Regulatory, Planning and Assessment.MBisson/GMansfield
Reference: SDC2021/0007.01
Phone: 02 4974 2000

NEWCASTLE CITY BYPASS (SSI-6888-MOD-1) – ADDITIONAL ANCILLARY FACILITIES

I refer to the Department's notification of 11 June 2021 advising that Transport for NSW (TfNSW) has submitted an application to modify the approval (SSI-6888) for the Newcastle Inner City Bypass-Rankin Park to Jesmond. The proposed modification is for four additional construction compounds to support the project and updates to compliance monitoring and reporting conditions. The Department has requested City of Newcastle (CN) to provide advice on the application.

Figure 6 | Extent of the vegetation to be cleared at Peatties Road (Modification Submission Report 2021)

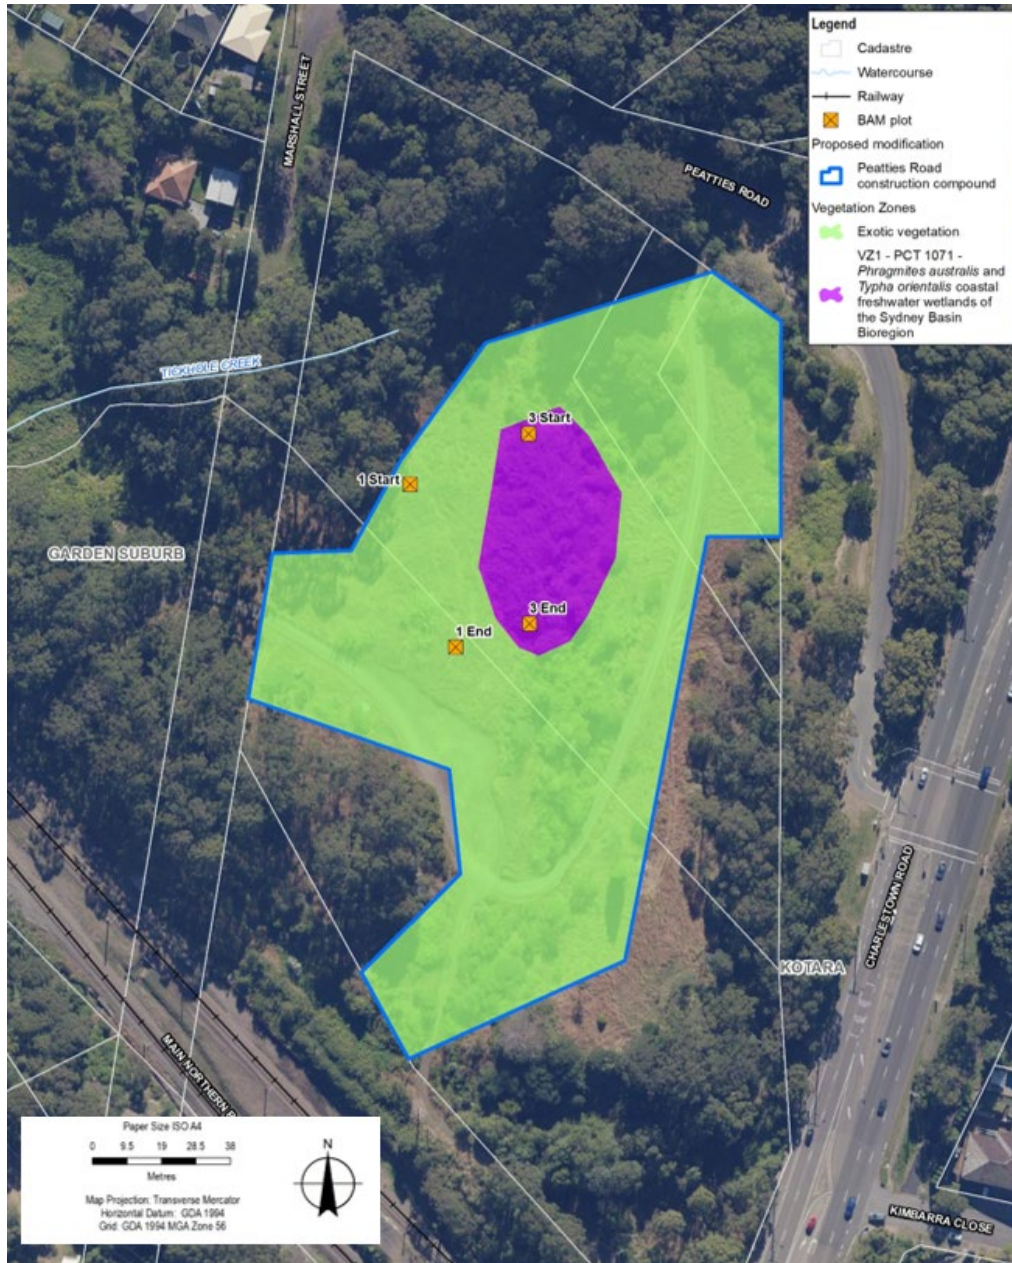
- Focus is needed on the proposed buffer zone between the compound site and remnant vegetation to manage potential edge effects.
- No new direct stormwater connection or increase in overland flows into the creek line on the western boundary of the property are permitted. This includes any final surface grading of the old quarry area.

- Figure 4c (attached) does not accurately map Tickhole Creek. For the reason above, minor adjustment of construction compound boundary is recommended so that the area marked up in red stripes (refer Fig 4c) is not disturbed and rehabilitated with a protective buffer of vegetation.

Figure 3 – Indicative drainage line protection area (in light blue) downstream of the Peatties Road culvert (**Condition E89**)

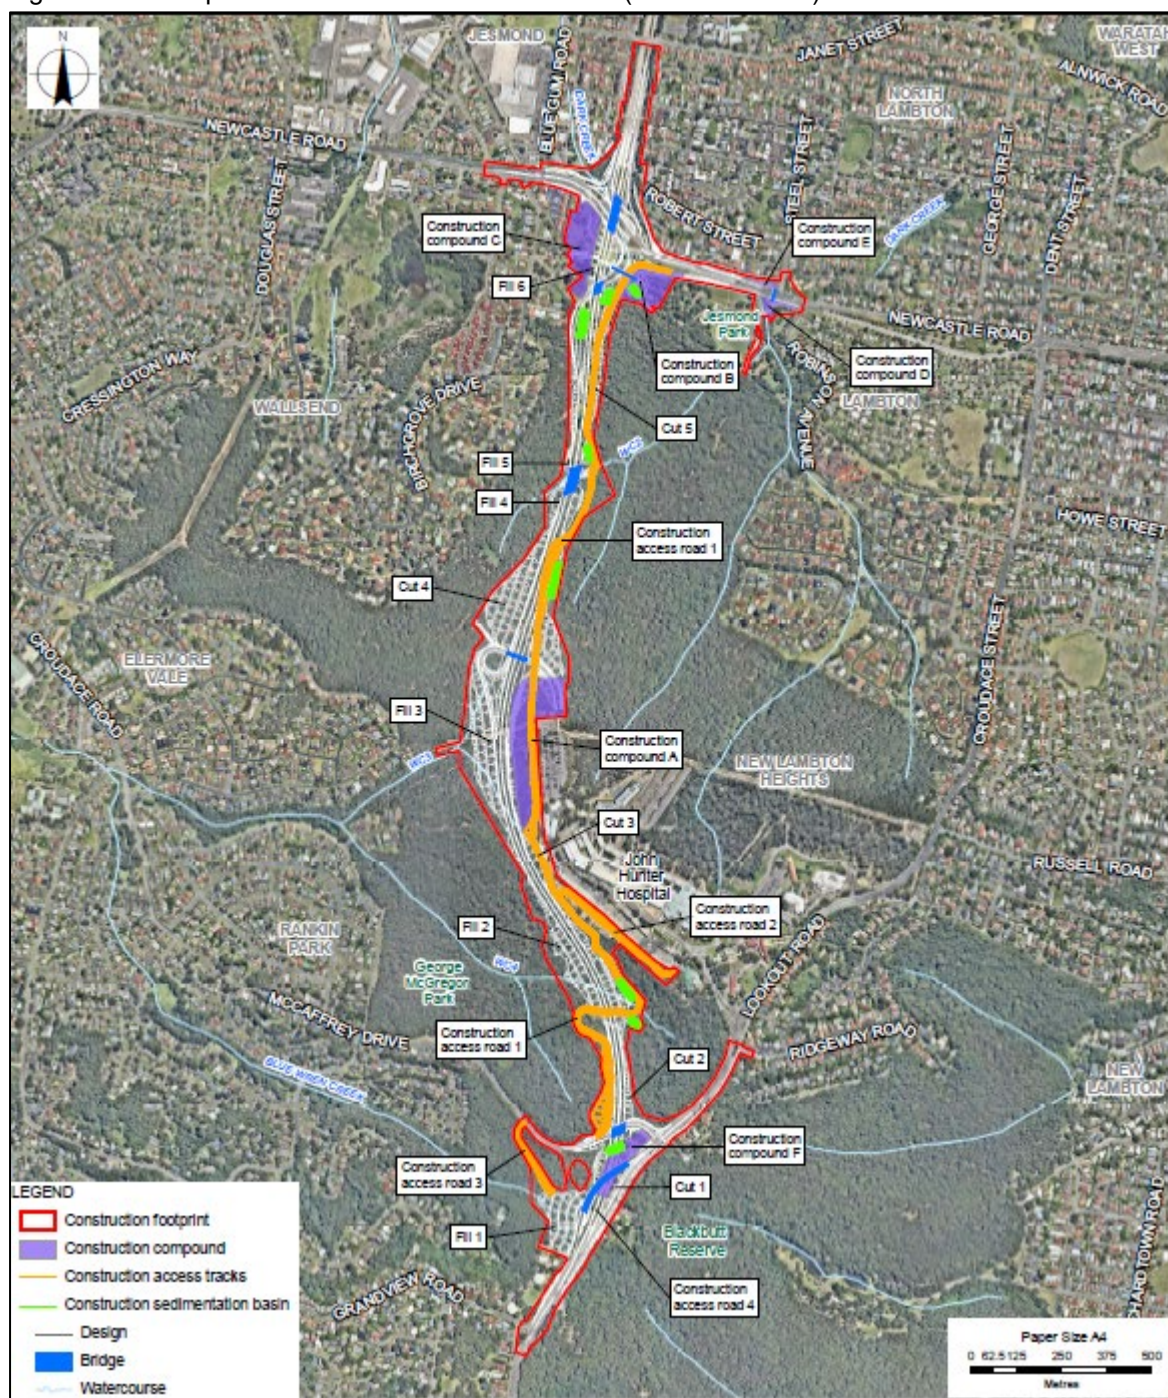
- The drainage design of any new entrance works to build a suitable access road off Peattie's Road must protect the creek line shown in aqua on the attached Figure 4b. The current culvert under Peattie's Road drops into a very steep rainforest waterfall gully. Any impacts to the stability of this drainage line will be very expensive to fix and CN does not want to be burdened with these works to protect Peatties Road, the only access road to the residents to the west.
